Head of Planning Services
Kirklees Metropolitan District Council
P.O. Box B93
Civic Centre
Huddersfield
HD1 2JR

Your Ref: 2018/92686
Our Ref: U014048

127, Westgate, Heckmondwike, - Outline application for erection of retail (A1) and drive thru restaurant (A3) development and associated car parking, landscaping and infrastructure

Thank you for consulting Yorkshire Water regarding the above proposed development. We have the following comments:

File Identifier	Project	Originator	Volume	Level	Type	Role	Number	Revision
WFFL - MWA - 01 - GF - DR - A - 0003	P1

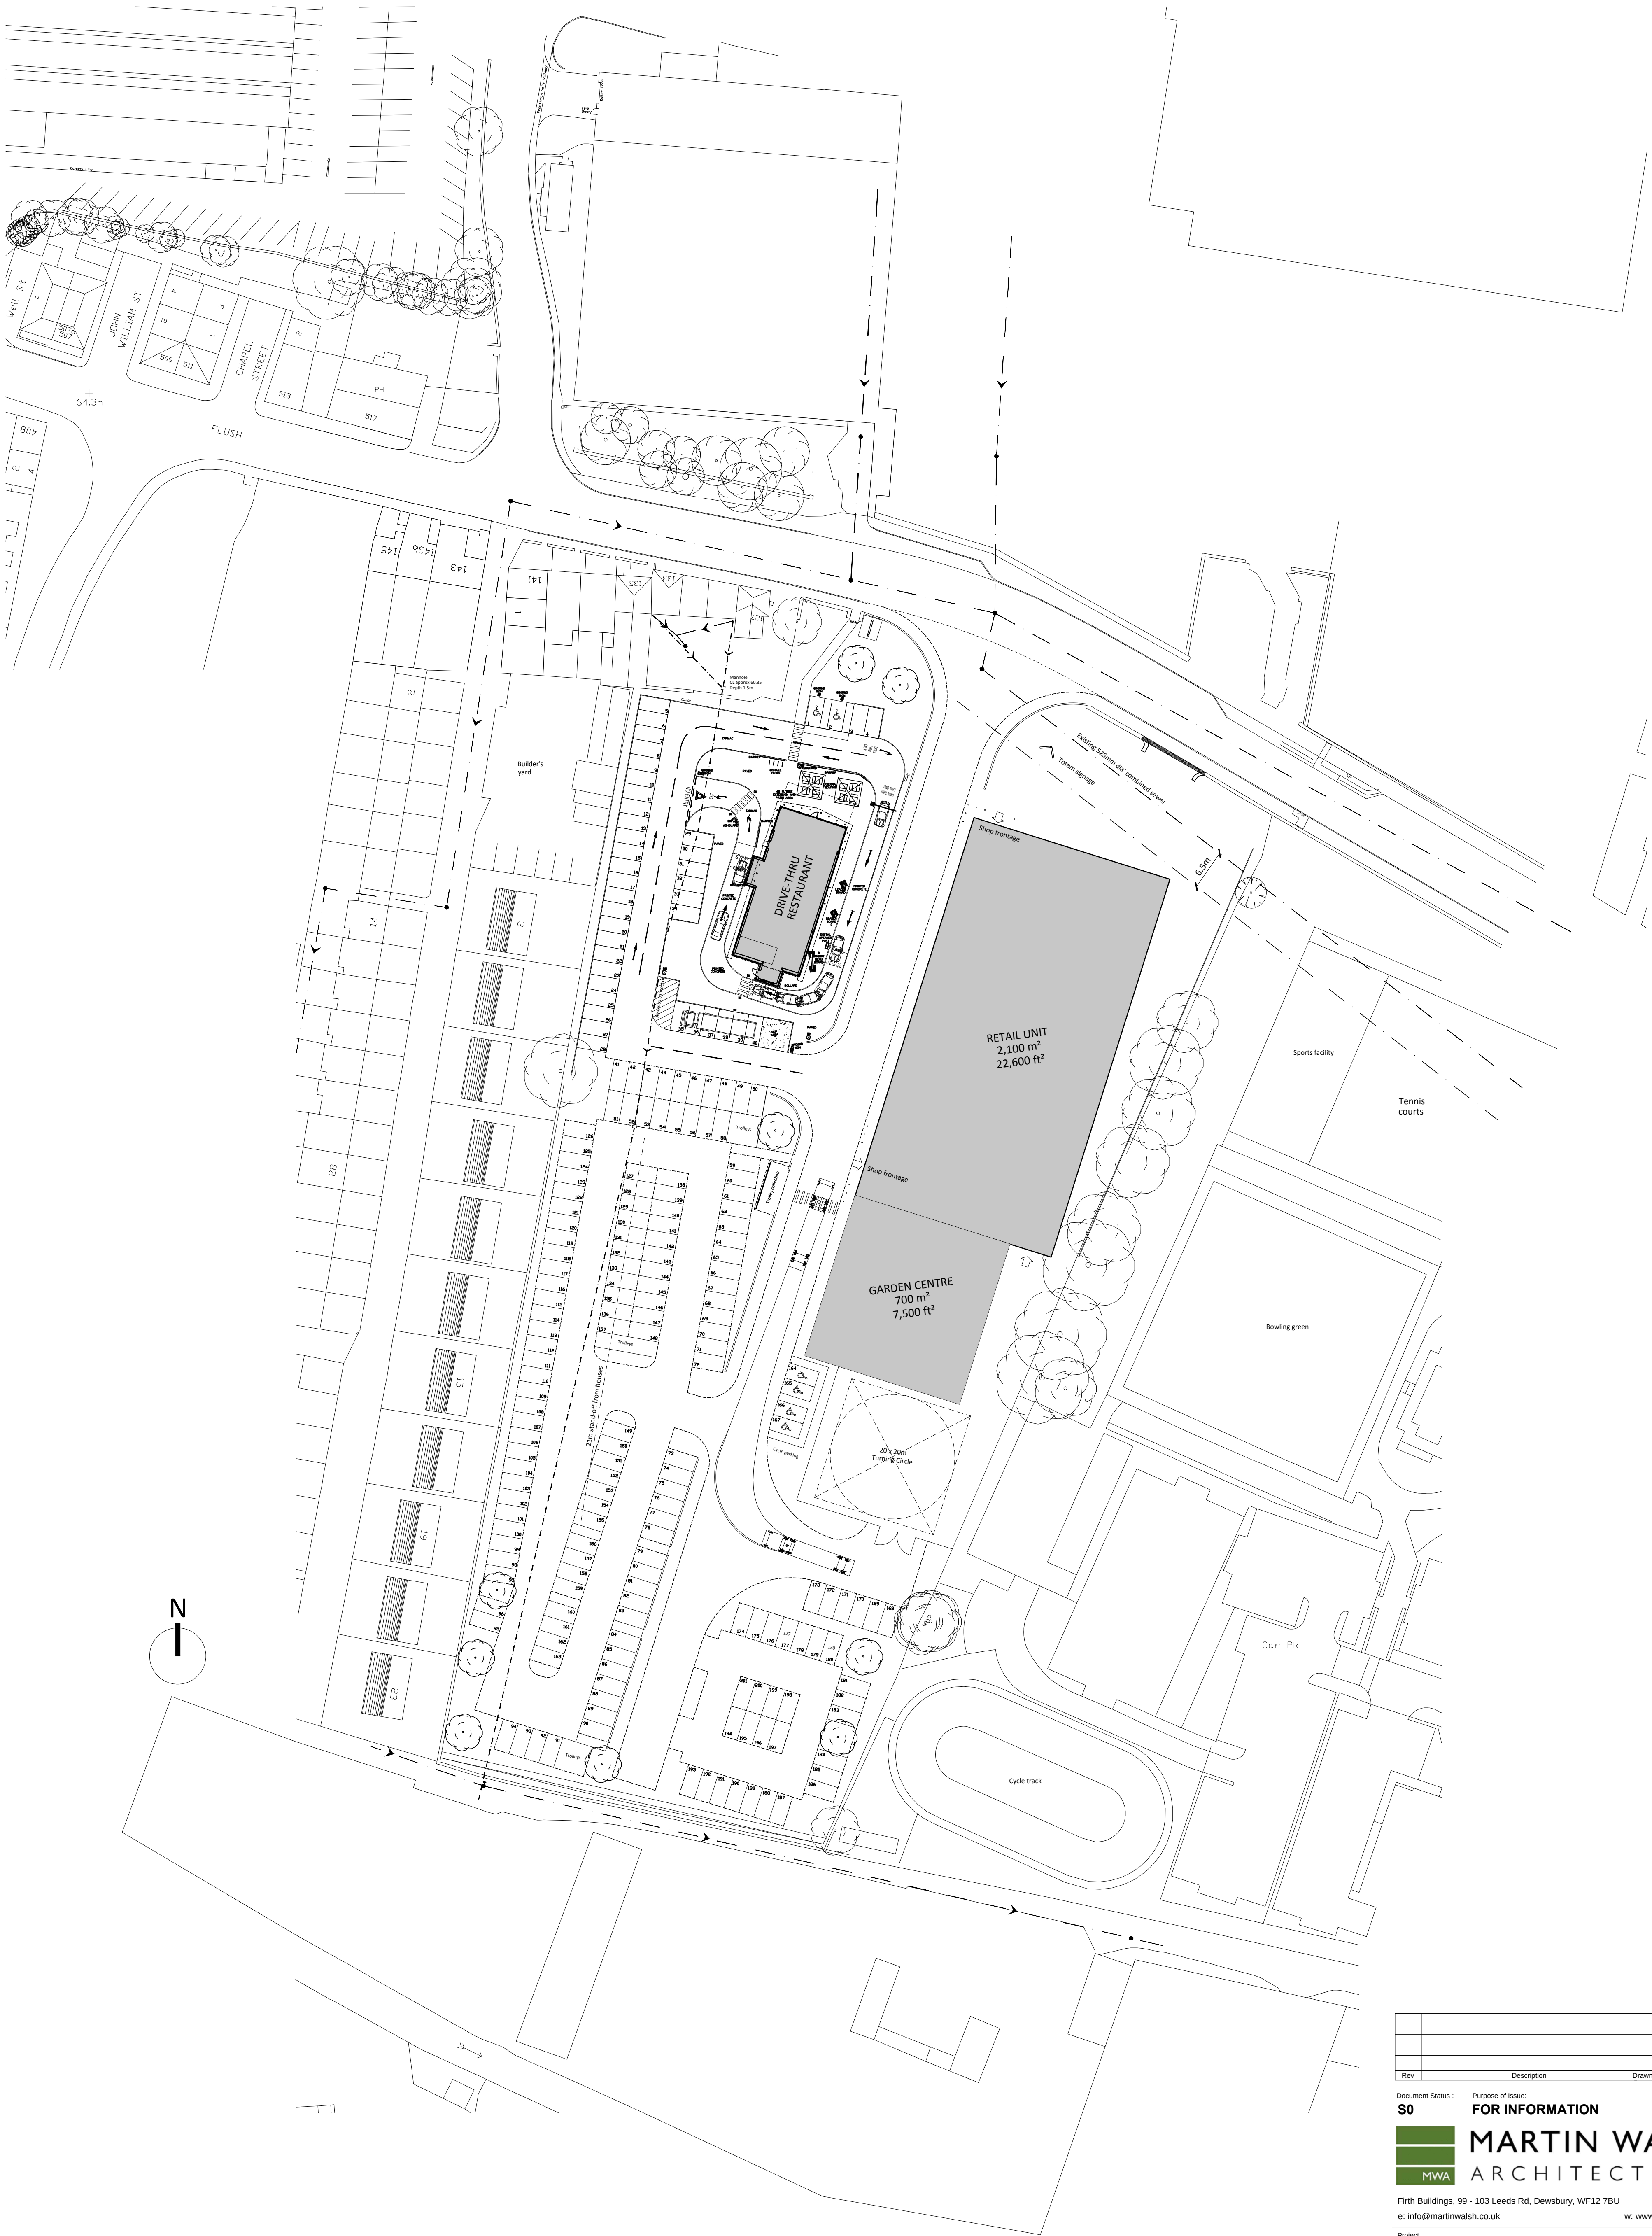
2) On the Statutory Sewer Map, there is a public combined sewer of unknown diameter recorded to cross the site. It is essential that the presence of this infrastructure is taken into account in the design of the scheme. The proposed building stand-off from 525mm diameter public sewer centre-line of 6.5 (six point five) metres submitted on drawing 0003 (revision P1) prepared by Martin Walsh Architectural shows that the required protective strip around the sewer has been observed.

Risk Assessment (Report E17/6946/FR01 dated June 2017) and drawing no. 0003 (revision P1) YW
has no further comment on this application
